State of Washington  
DEPARTMENT OF FISH AND WILDLIFE

June 3, 2022

**SUBJECT: WDFW COMMENTS ON CU-22-00002 CALVARY ELLENSBURG**

**Figure 1.** The blue line generally traces the path of East Branch Lyle Creek flowing into and off Calvary Ellensburg properties.

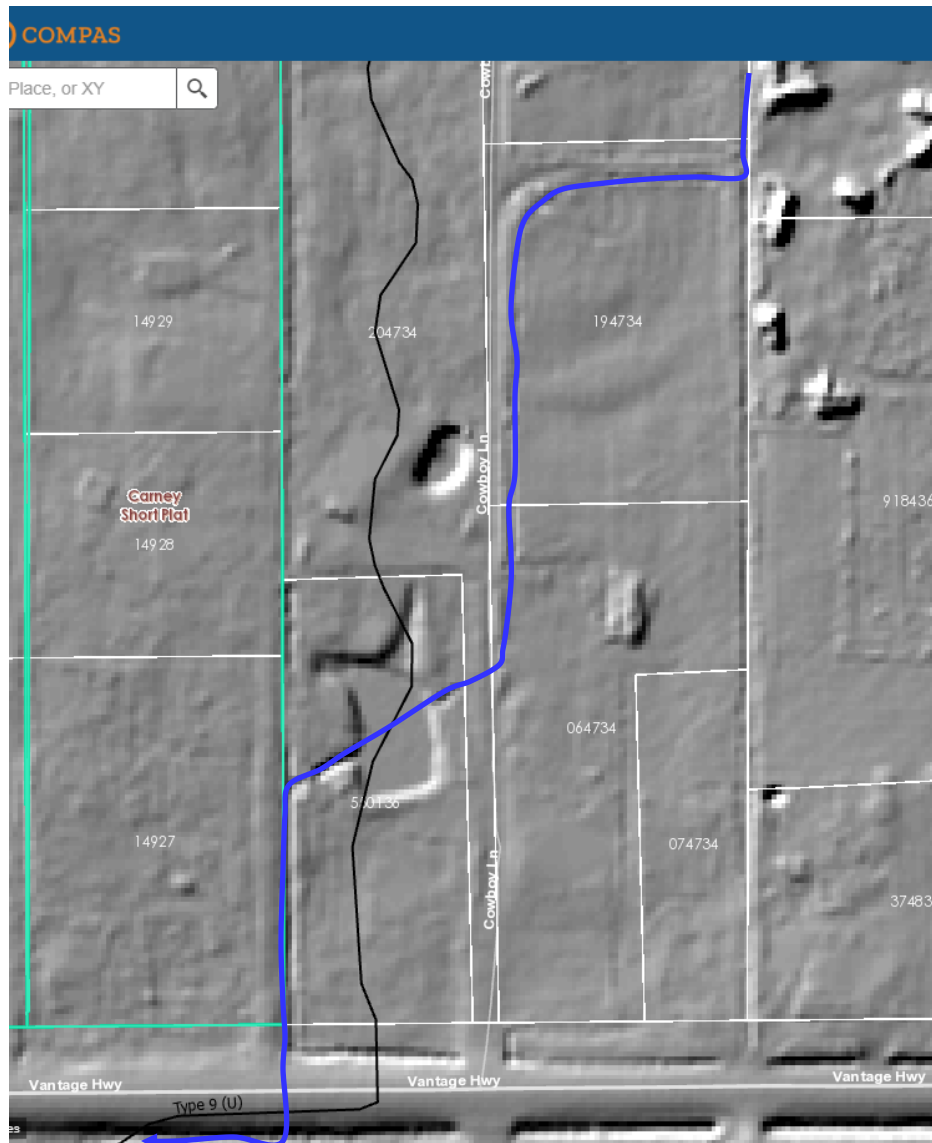
Thank you for the opportunity to comment on the proposed Calvary Ellensburg project near East Branch Lyle Creek. East Branch Lyle Creek is a branch of Lyle Creek starting along Judge Ronald Road. It flows south and continues west along the northern portion of Calvary Ellensburg's property before heading south and crossing Cowboy Lane to the west and eventually crossing Vantage Highway before rejoining the main branch of Lyle Creek near the Palouse to Cascades Trail. The stream layer on COMPAS does not accurately reflect the location of this channel, but the approximate location is easier to see in LIDAR and in Figure 1 below.

The Washington Department of Fish and Wildlife (WDFW) acknowledges that East Branch Lyle Creek may be managed for irrigation deliveries, but it is currently unscreened at Judge Ronald Road where the upstream extent of East Branch Lyle diverts from the main branch of Lyle Creek and it flows perennially. As such, WDFW recommends East Branch Lyle Creek be treated as a fish bearing stream with appropriate setbacks or that a fish screen meeting WDFW criteria to prevent fish entrainment into this channel be designed and constructed such that fish are no longer entrained into East Branch Lyle Creek. WDFW will be pleased to work with the project proponents to evaluate options and help accomplish their goals for their property.
